File No. : **CMDA/PP/NHRB/S/0666/2022**

Sub: CMDA-Area plans Unit - NHRB (South) – Planning Permission for the proposed construction of Stilt floor + 4 floors + 5th floor (Part) (18.30m height) Residential Building with 59 dwelling units for Affordable Housing at Medavakkam, Chennai comprised in S.No.136/1A1B, 136/1C, 136/1D1, 136/2B1A & 136/2C1A of Medavakkam Village within the limit of St. Thomas Mount Panchayat Union - Approved and forwarded to Local Body for issue of Building Permit - Reg

3. Two sets of approved Plans are Numbered as **OL-PP/NHRB/0302/2023** dated **07/08/2023** in **Planning Permit No. OL-00442** are sent herewith. The **Planning Permit** is valid for the period **from 07/08/2023 to 06/08/2031**.

SITE CUM STILT FLOOR PLAN

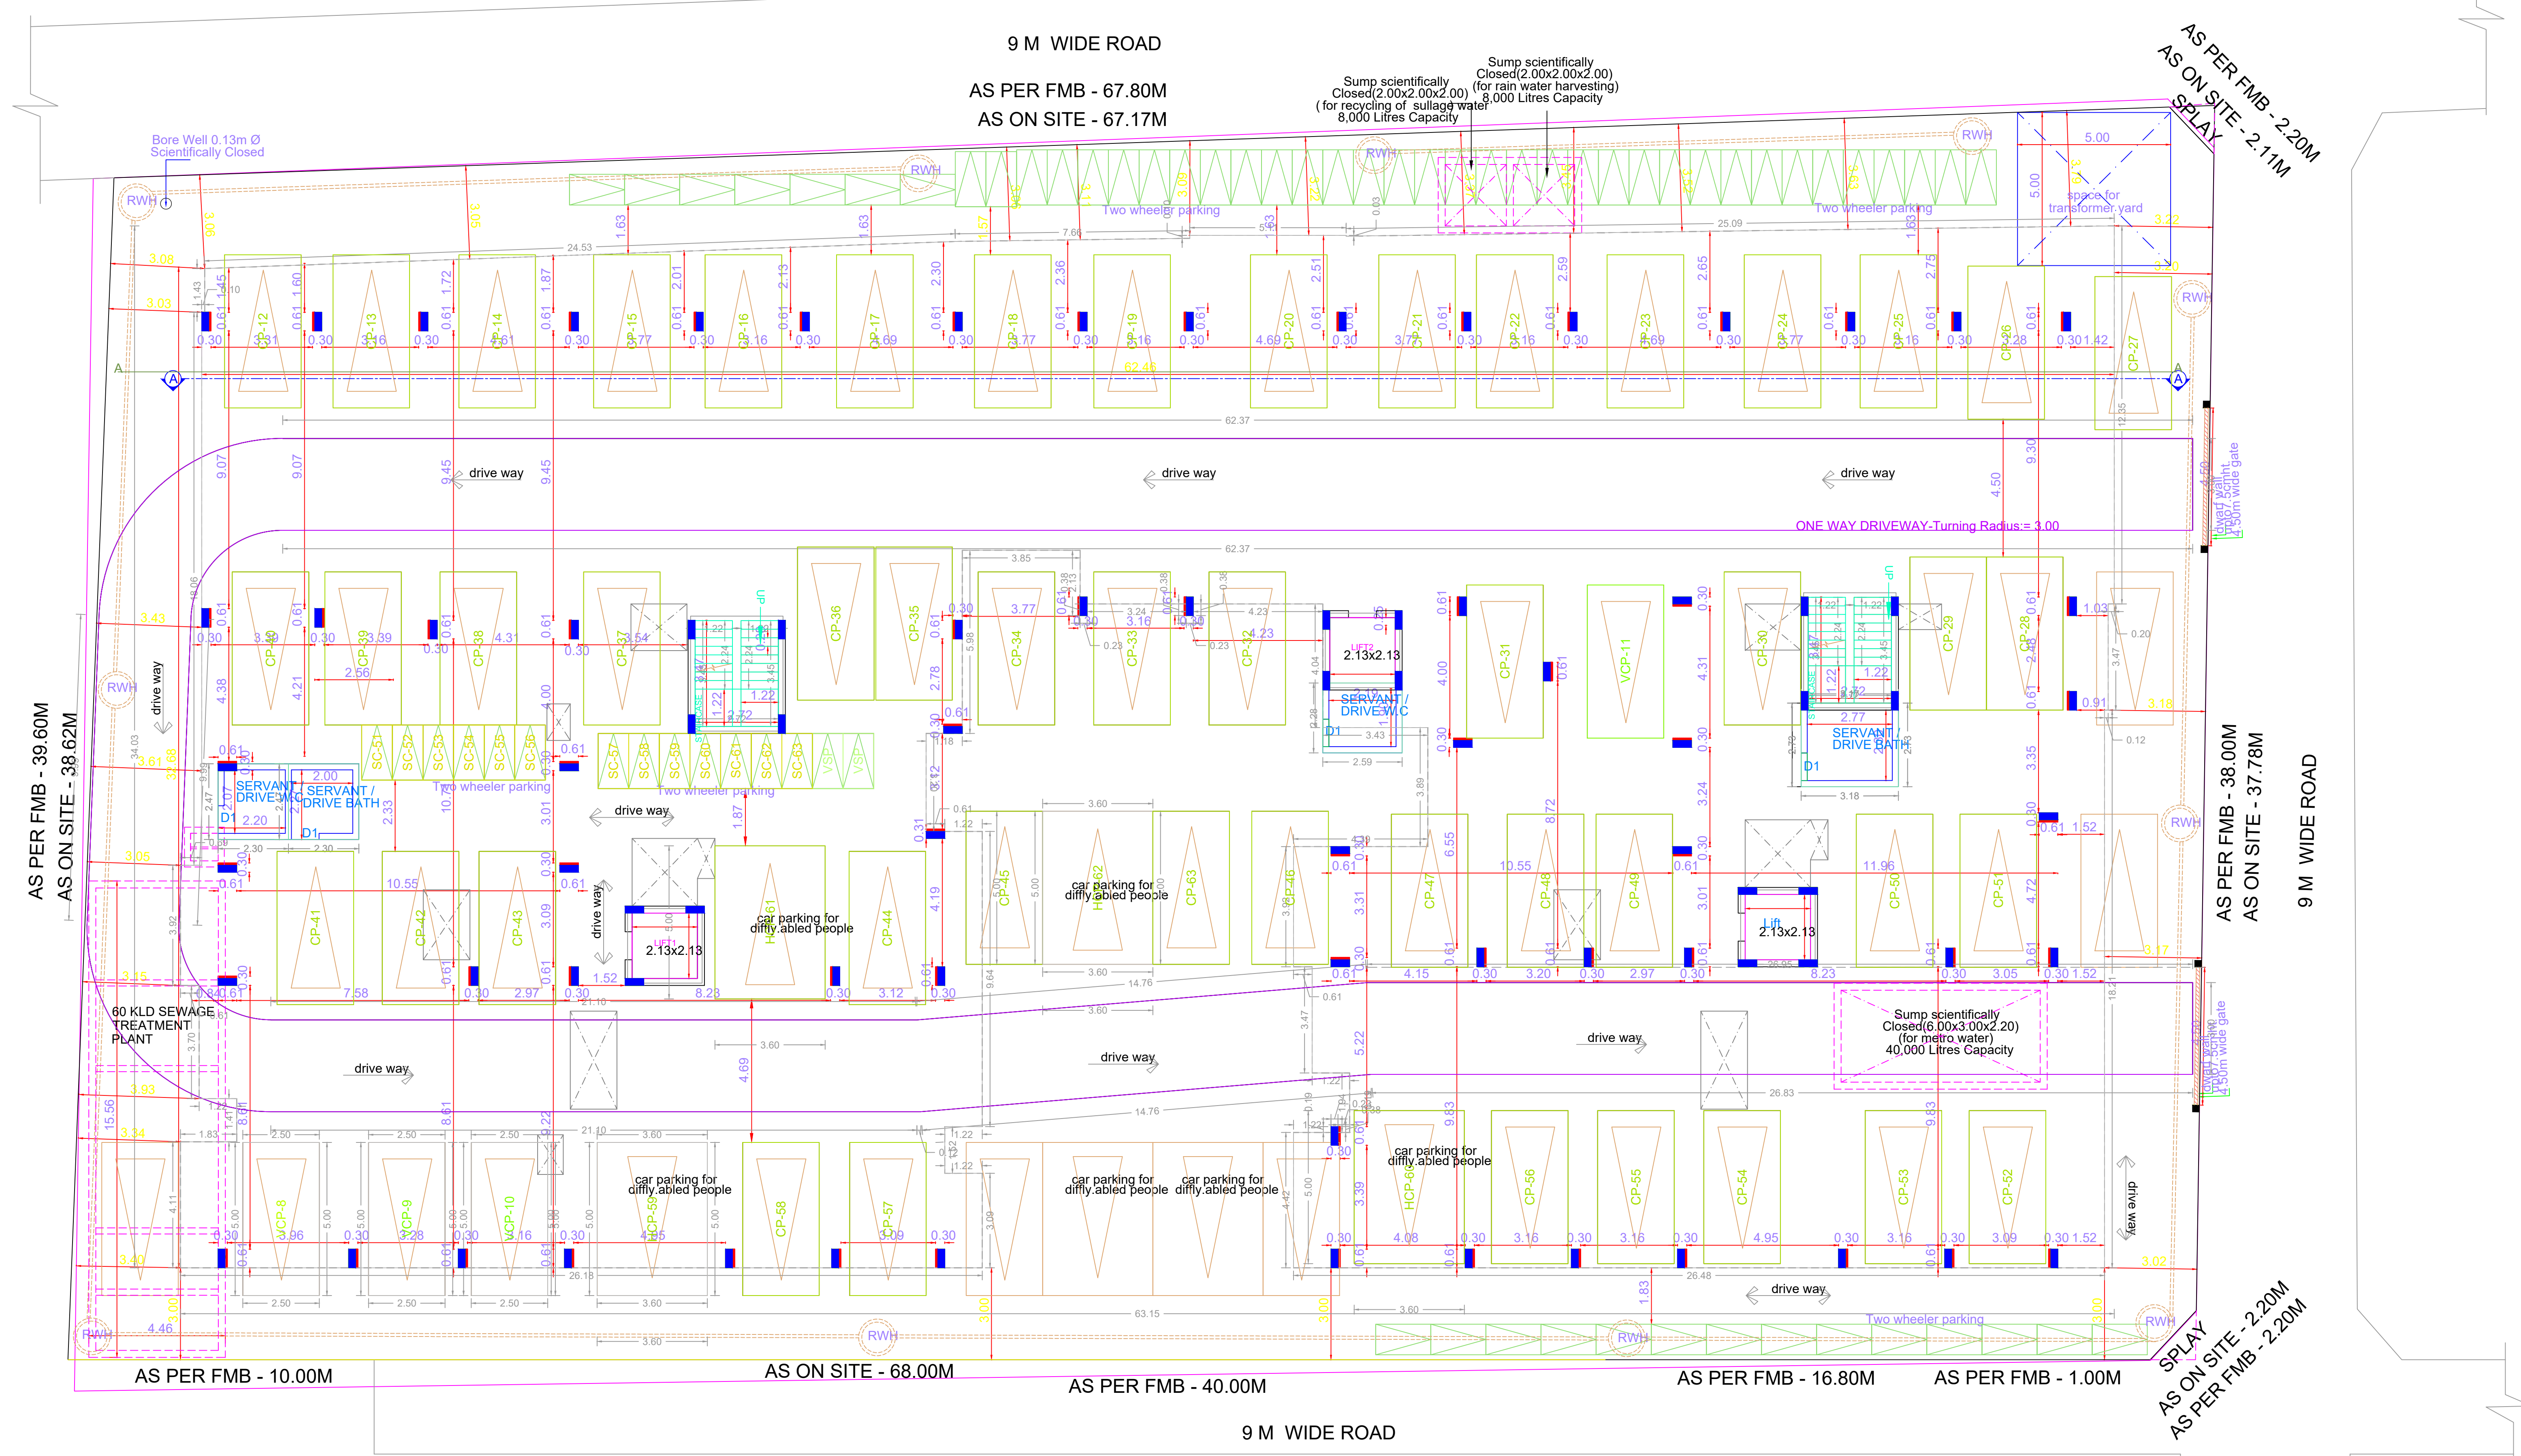
- (ii) The continuous architectural slab projection shown in the stilt floor, 4th floor, and Terrace floor level is permitted only for the construction of the Pergola.
